**Consultation Response from Mike Hibbert,
KC Waste Strategy(Refuse & Recycling)**

2024/92779 land at Providence Street, Earlsheaton, Dewsbury, WF12 8HZ

Outline application for residential development

Responding Ref: WPN 24-043

DRAWING:
ILLUSTRATIVE MASTERPLAN

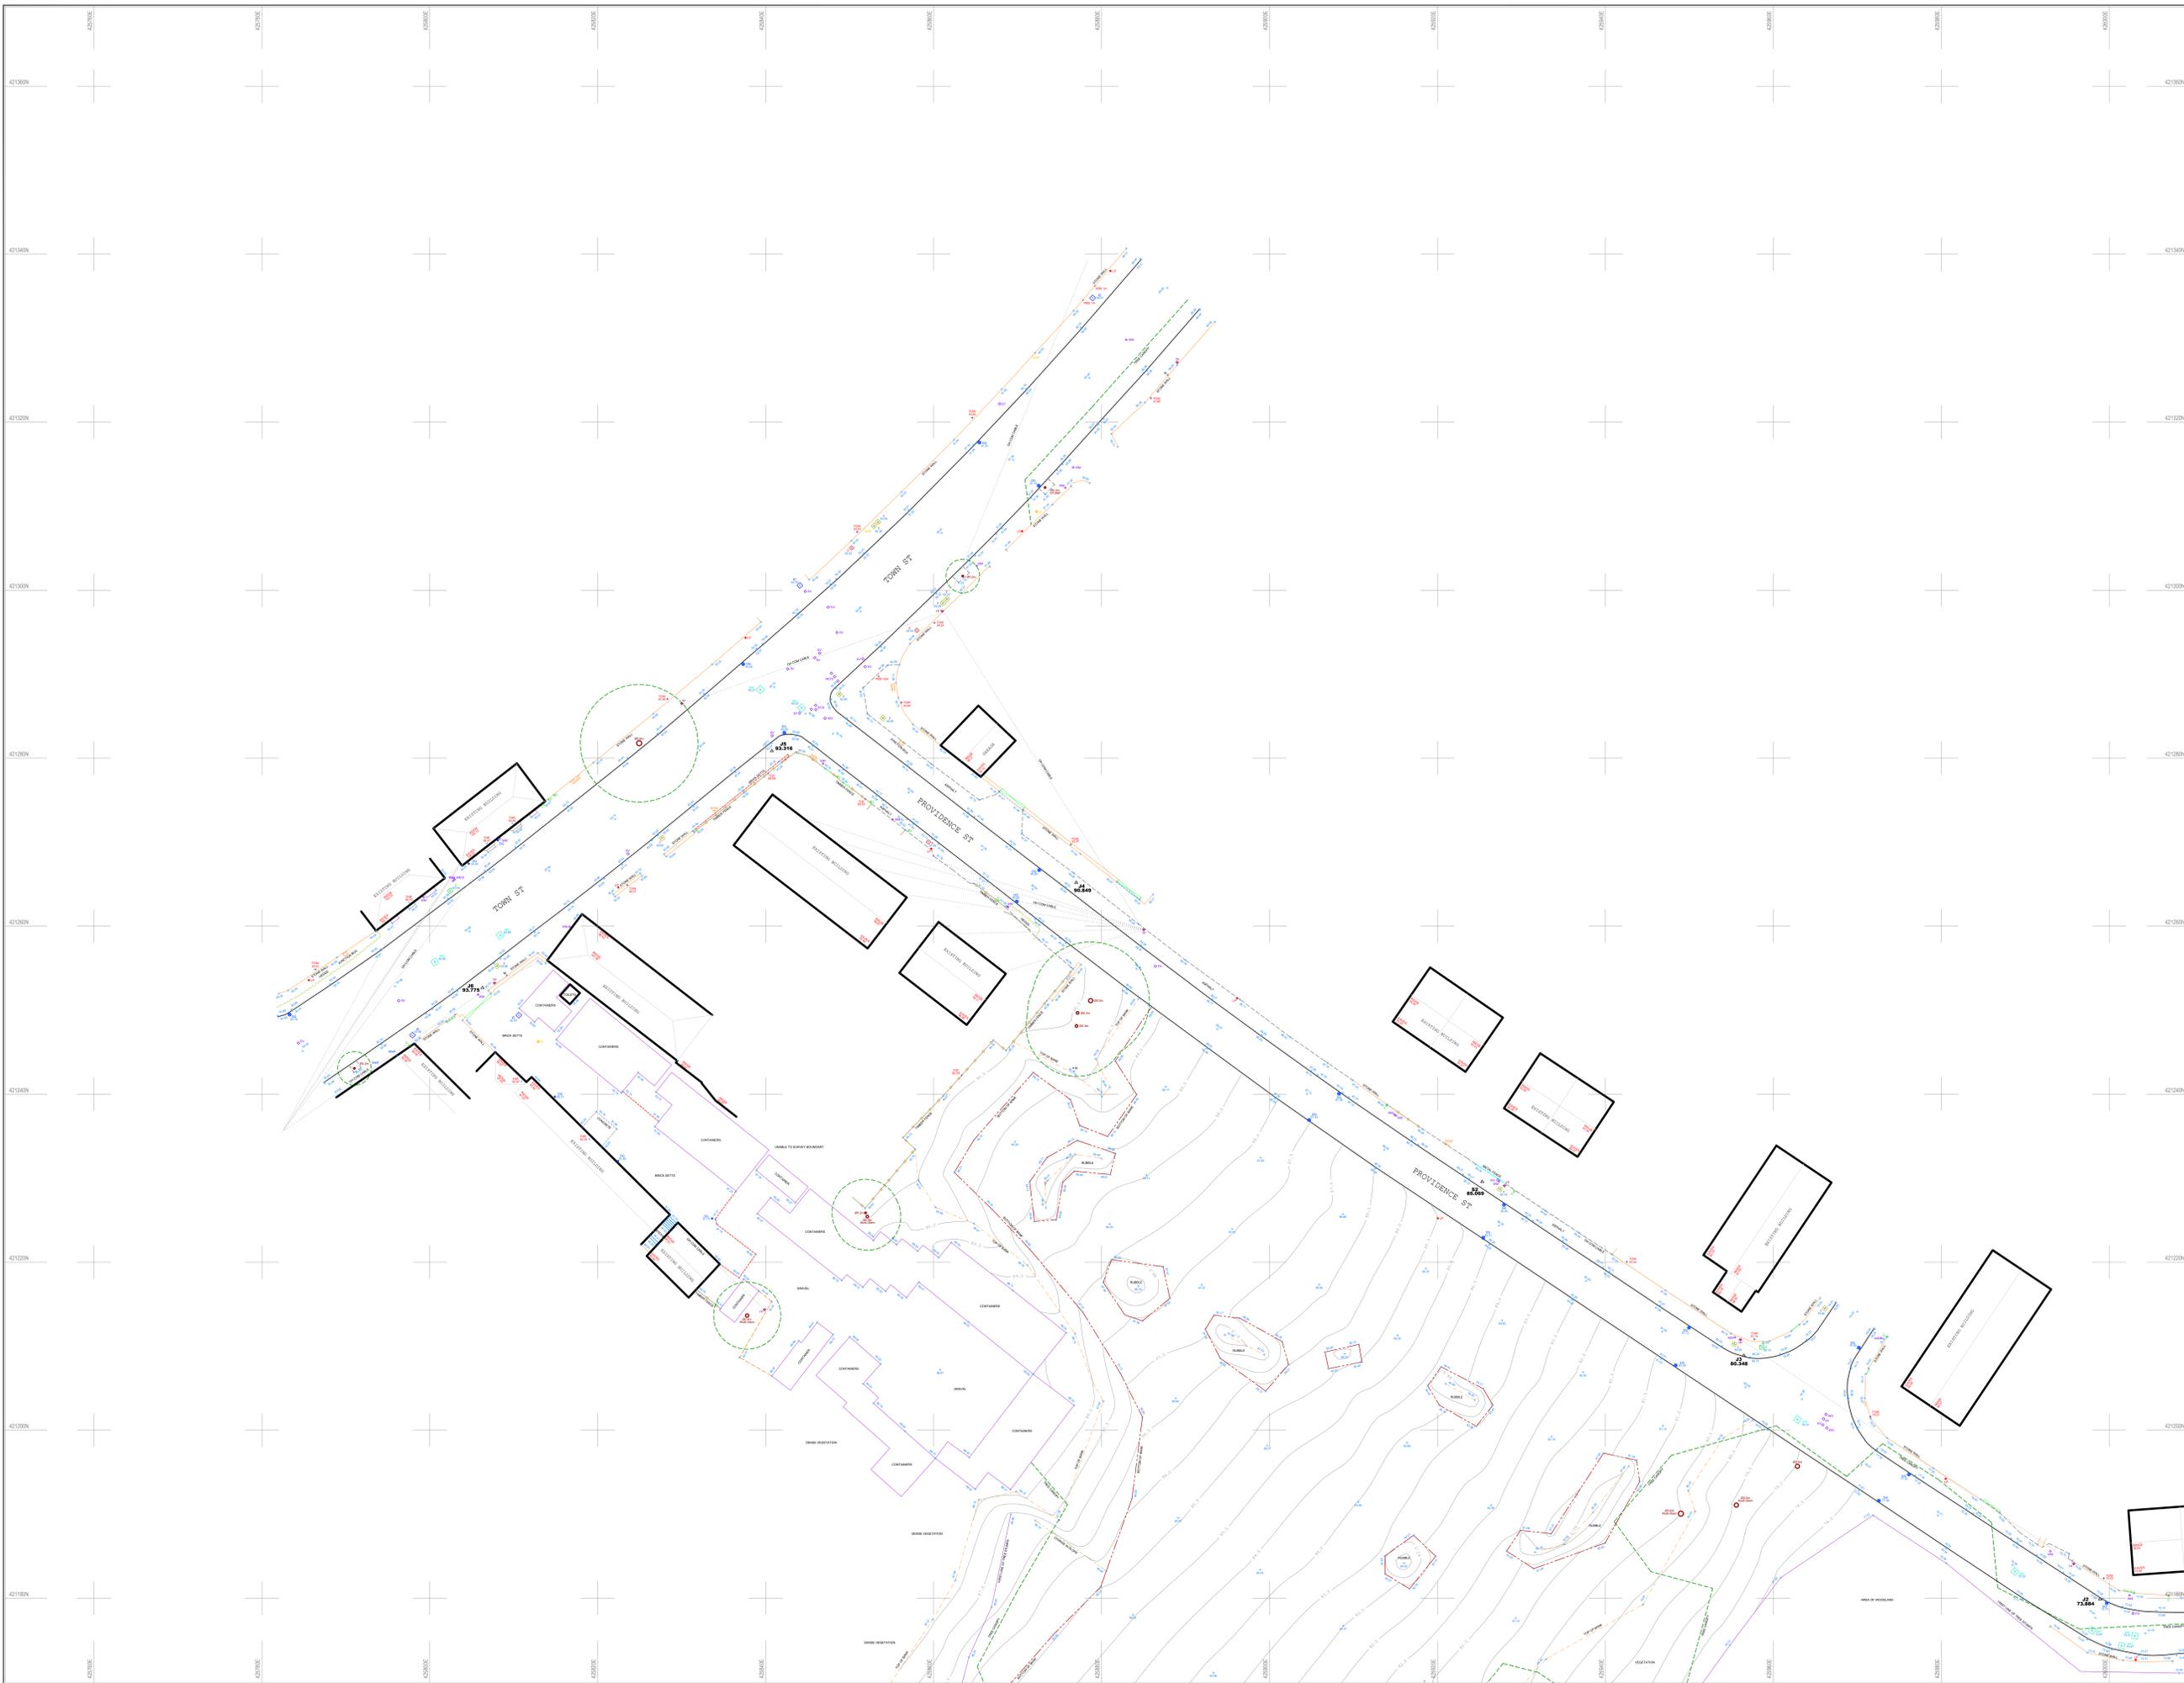
This outline application relates to a development of up to 30 dwellings. The applicant has submitted an Illustrative Masterplan Drawing Number 24 5721 02 Coloured Dated August 2024 that shows the proposed site layout. The topography of the site falls in a southeasterly direction ranging between approximately 63.0m to 93.5 m AOD that provides constraints on the arrangement of properties within the site.

- There is no indication of space for the presentation of bins on collection day. It is important to ensure that bins do not cause obstruction to pedestrians or other highways users when presented for collection, particularly where space requires these to be left in clusters. Bin presentation space should be identified for each plot, on a hard surface and where a refuse collection vehicle (RCV) can be easily reached.

- The WCA will not take a Refuse Collection Vehicle onto private drives. The layout plan must show the location of Bin Collection Points (BCP's) for presentation of wheeliebins adjacent to the adopted highway. Bin Collections Points will be required for Plots located of the Southern end of the lower access road. Guidance BS5906:2005 specifies that the maximum drag out distance from the property to the Bin Collection Point (BCP) is 25m.

- **The WCA has a strong preference for looped roads rather than use of turning heads.**
- Suitable site access and manoeuvrability space for a Refuse Collection Vehicle is vital to the Council's ability to discharge its obligation to collect waste from domestic properties. This obligation will exist in perpetuity on any residential development and as such will be a critical consideration in the layout of the site.

- The road arrangement has angular road shapes that present difficulties for mechanical street cleaning, being a common area for litter and dirt to accumulate. This needs to be properly considered in any detailed proposals.

- Where turning is necessary, the turning facilities must be demonstrably sufficient for an 11.22m refuse collection vehicle. Active measures should be taken to prevent parking in the turning head of the lower access road as otherwise an RCV would have a long reverse manoeuvre to the entrance to the site on Providence Street that is a recognised safety risk and is not acceptable.

- The Authority will not take an RCV into private drives or roads that are not built to adoptable standards. Where the Plan shows shared surface streets e.g. block paving, confirmation is sought these are adopted/ constructed to adoptable standard.
